Lime Down Solar Park

**Planning Inspectorate Reference:
EN010168**

Wiltshire Council Closing Statement

Deadline 8 (16 October 2026)

Title:
Figure 3-1: Indicative Site Layout Plan

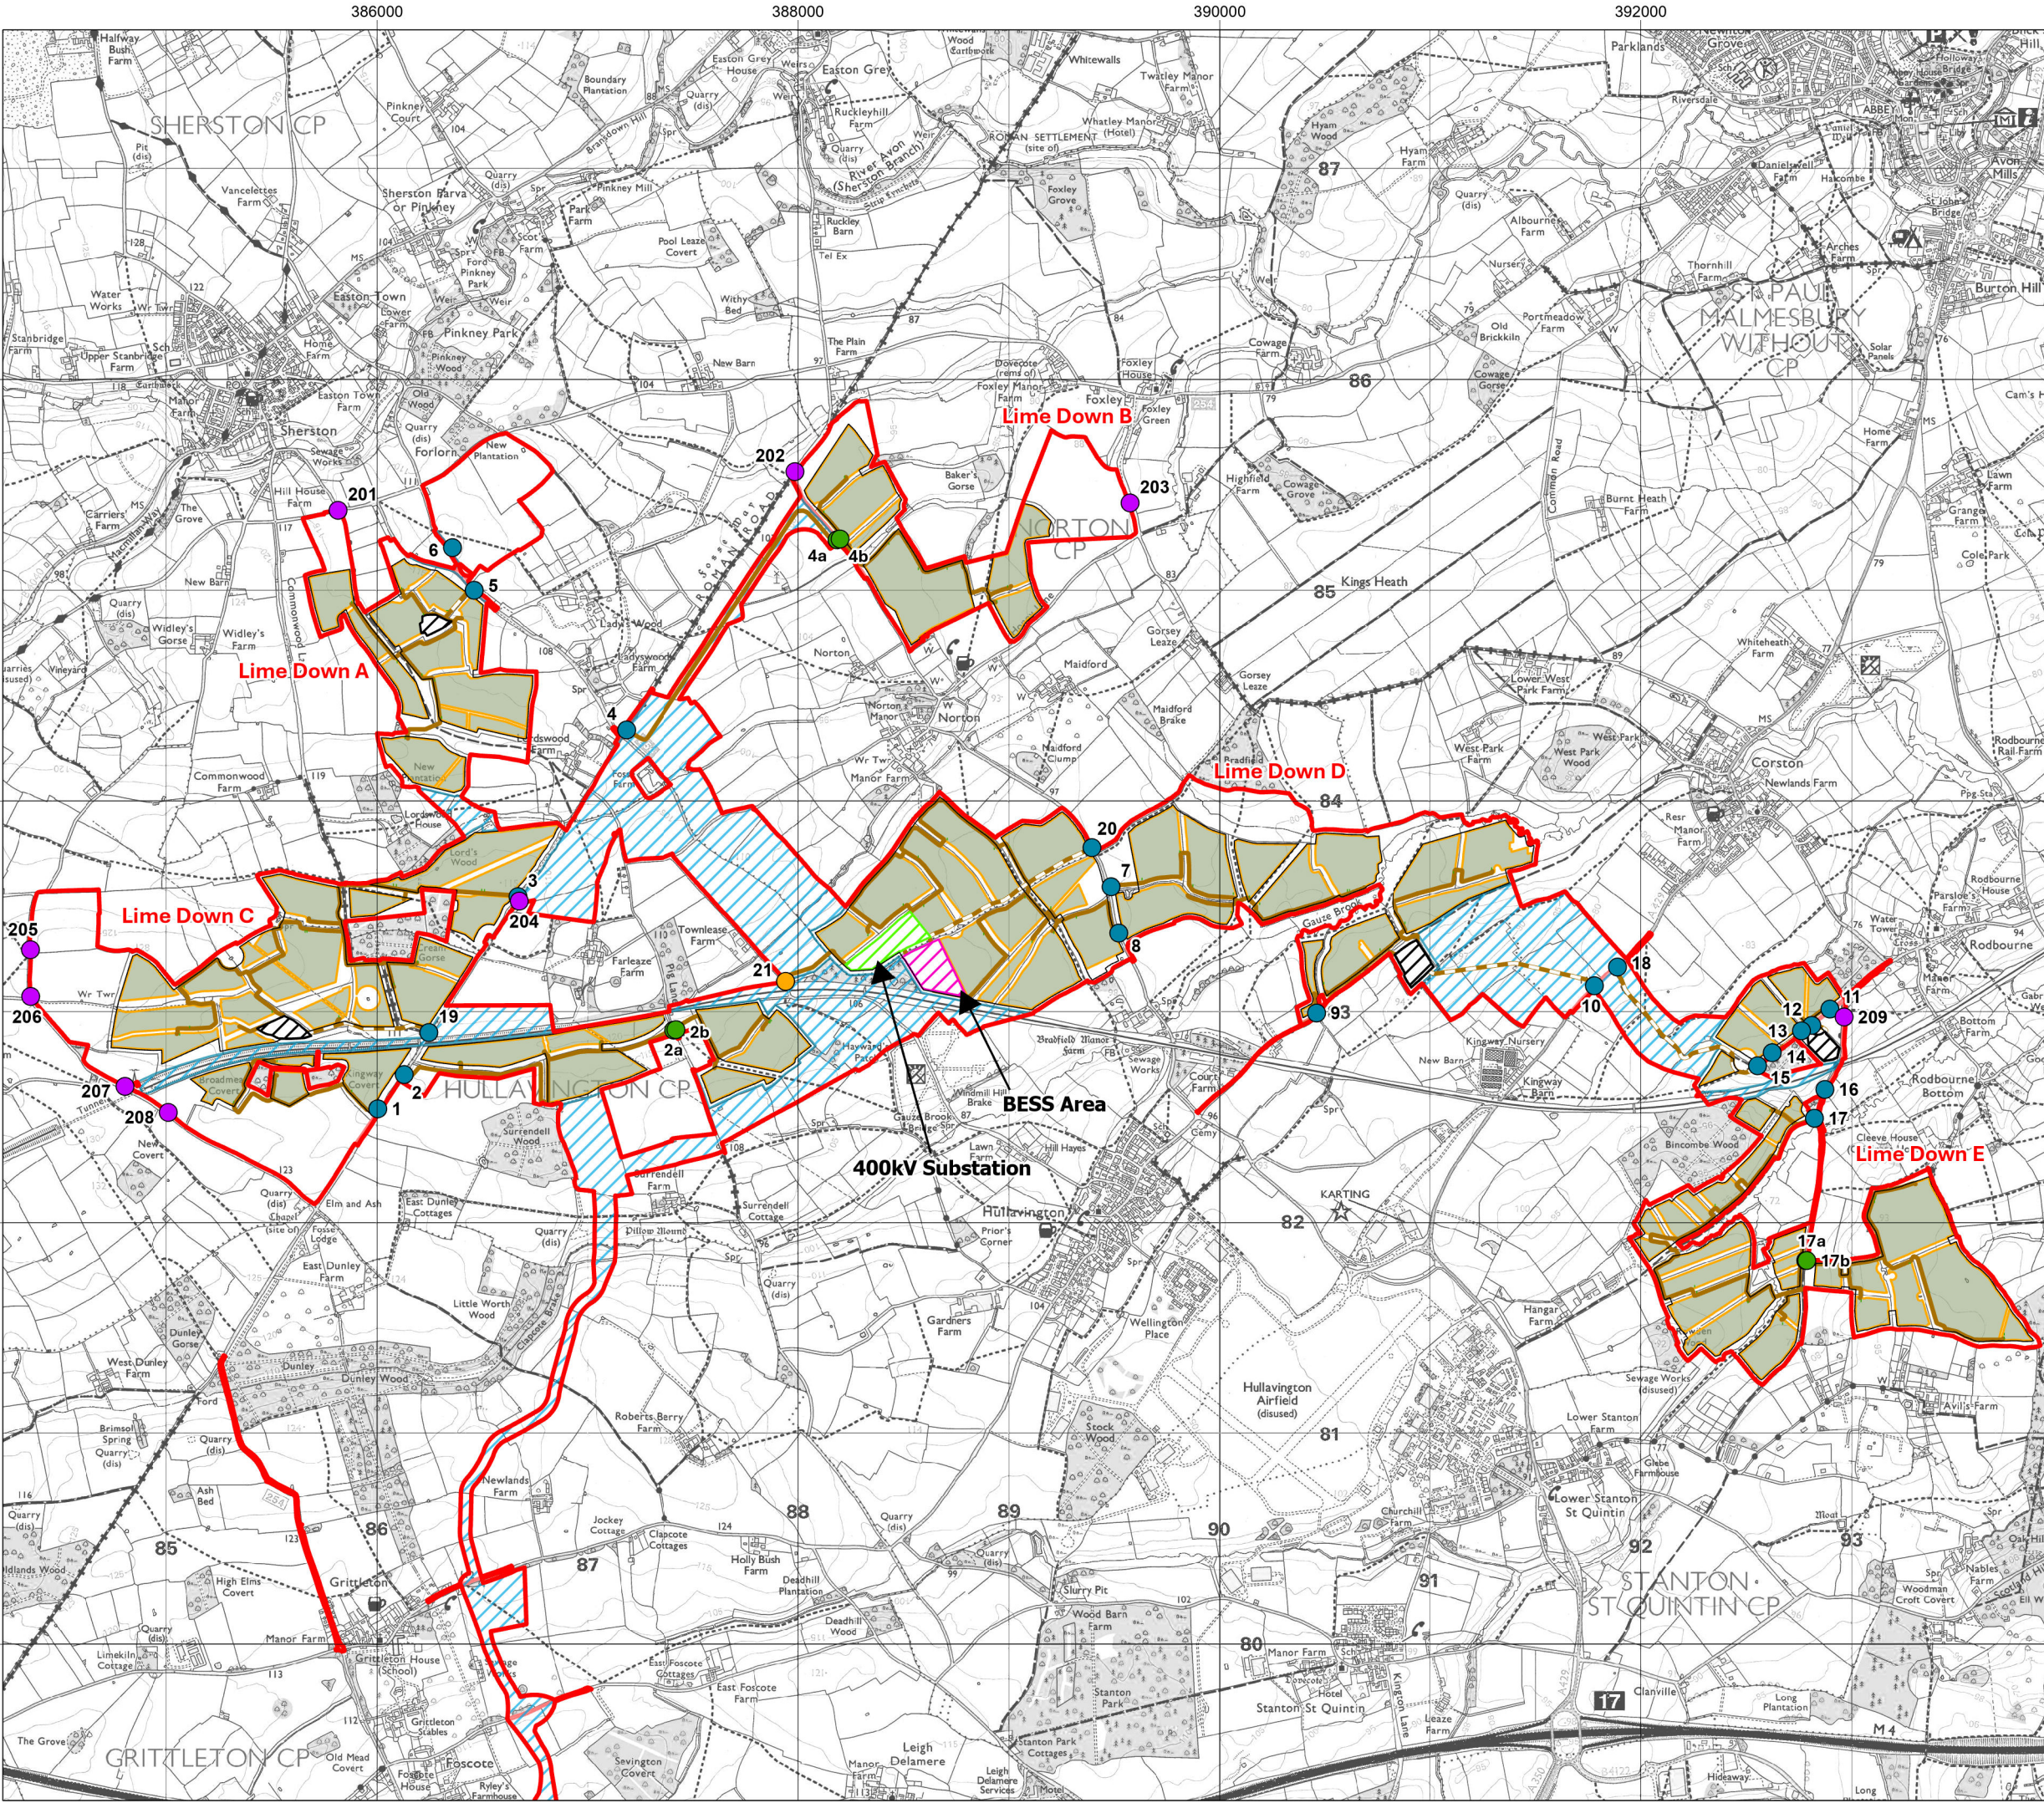
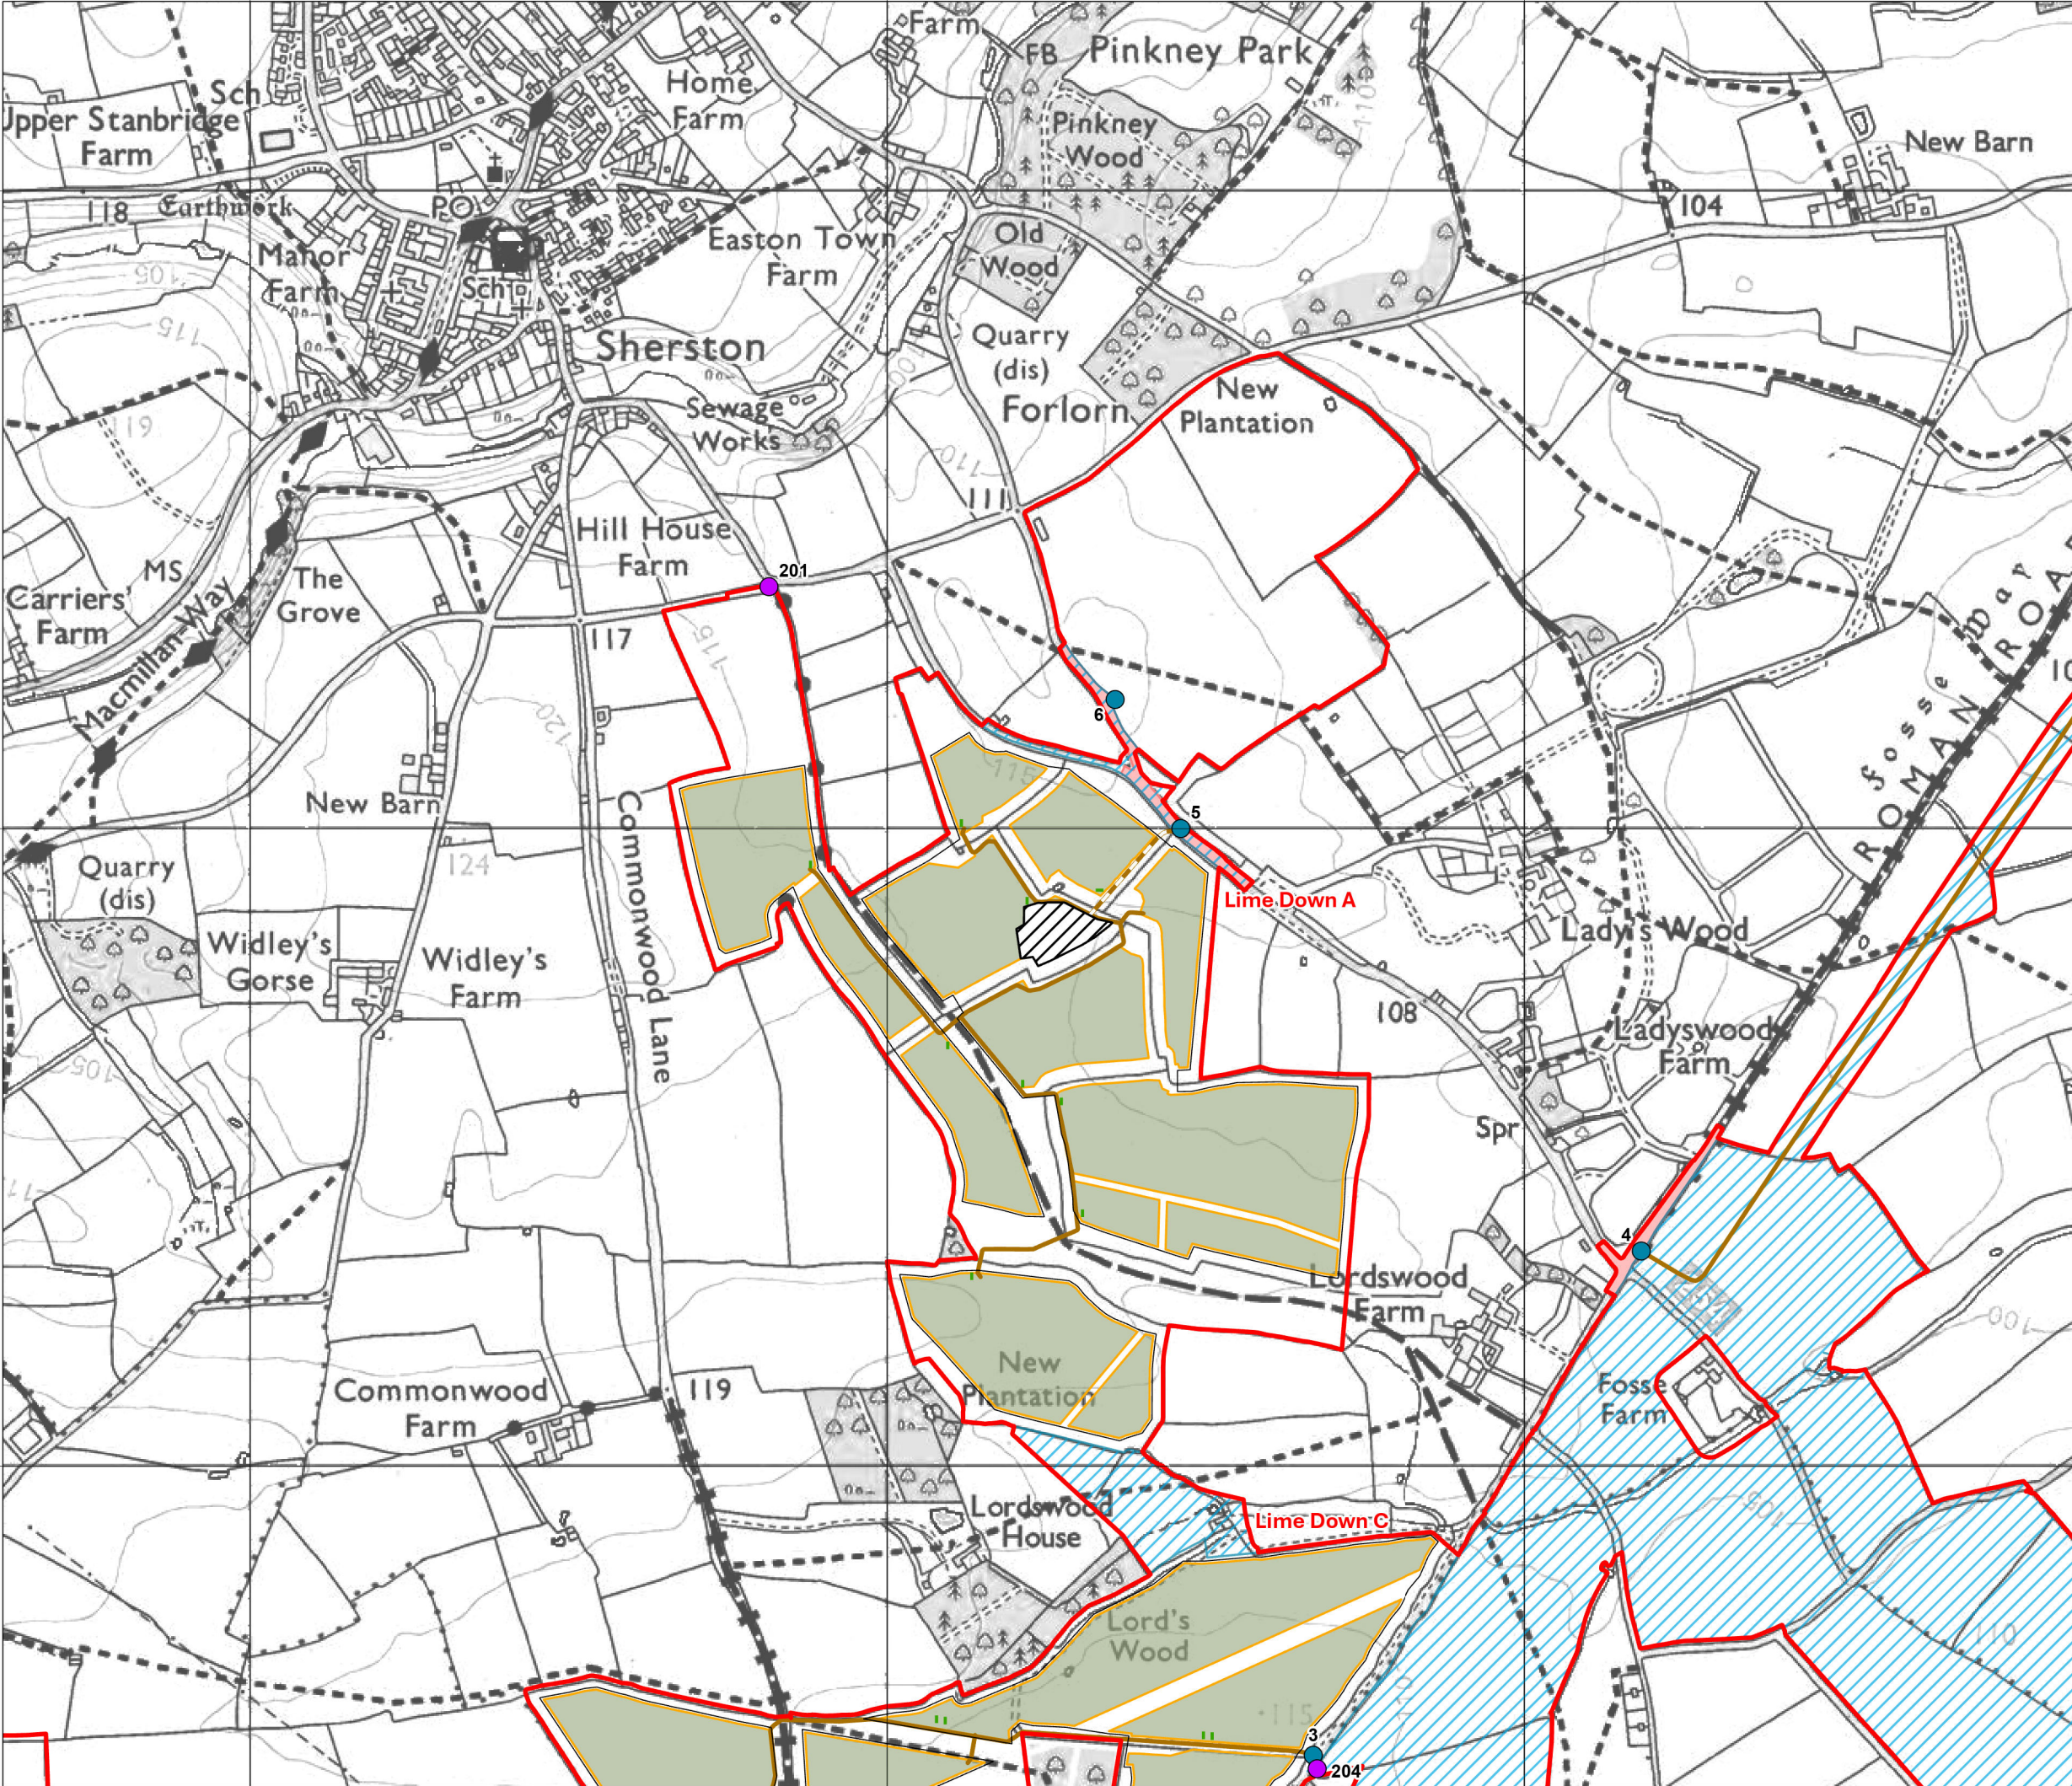
- 3.41. The council highlights that the figure still shows the southern part of Field A1 (Lime Down A) as a solar panel field area, despite its removal from the Landscape and Ecology Mitigation Plan (Rev 5) [[REP7-034](#)].
